Proposal: Repairs to main slate roof which is leaking. Will require lifting slates and relaying, replacing felt and battens. Materials will match existing and no changes other than like for like replacement

1.1. Burdrop House is an historic Grade II listed building located in the centre of Burdrop. The property was listed in 1988 and is within the Sibford Ferris Conservation Area.

2.1. Listed Building Consent is being sought for the repair of the main roof of the building. This is to involve the lifting of the existing slates, the replacement of felt and battens and the relaying of the slates.

BURDROF HOUSE MAIN ROOF 1:100

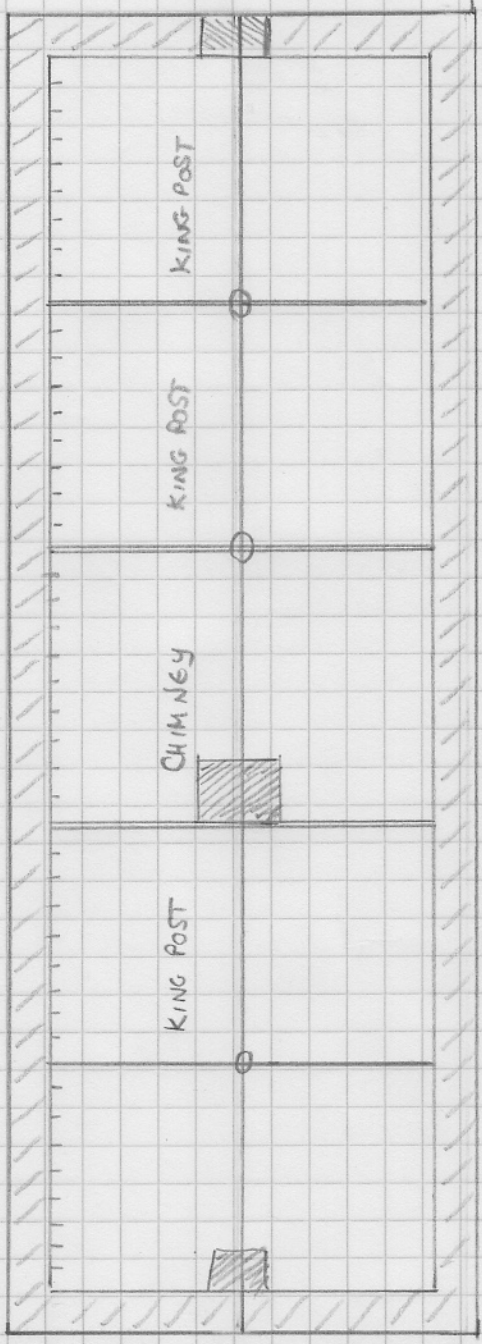
8.5. It is considered that the proposed works are sympathetic to the historic character of the building and are necessary given the current state of repair of the roof. The works would not result in harm to the significance of the historic fabric. It is, however, considered necessary to impose conditions regarding:

- the additional slates that may be required to complete the works i.e. product itself and how these slates will be distributed across the roof (mixed in with existing slate or utilised in one location).
- The use of breathable roofing felt.
- The use of lime mortar rather than cement to the stone copings, as cement could lead to a long-term maintenance issue whereby the stonework will erode rather than the impermeable mortar

3. Prior to the relaying of the slates details of any additional slates that may be required to complete the works and how they are to be distributed across the roof shall be submitted to and approved in writing by the Local Planning Authority. Thereafter, the development shall be carried out in accordance with the approved details.

4. All roofing felt used in the repair of the roof shall be breathable.

5. A traditional lime mortar mix shall be used for any repointing and repair works.
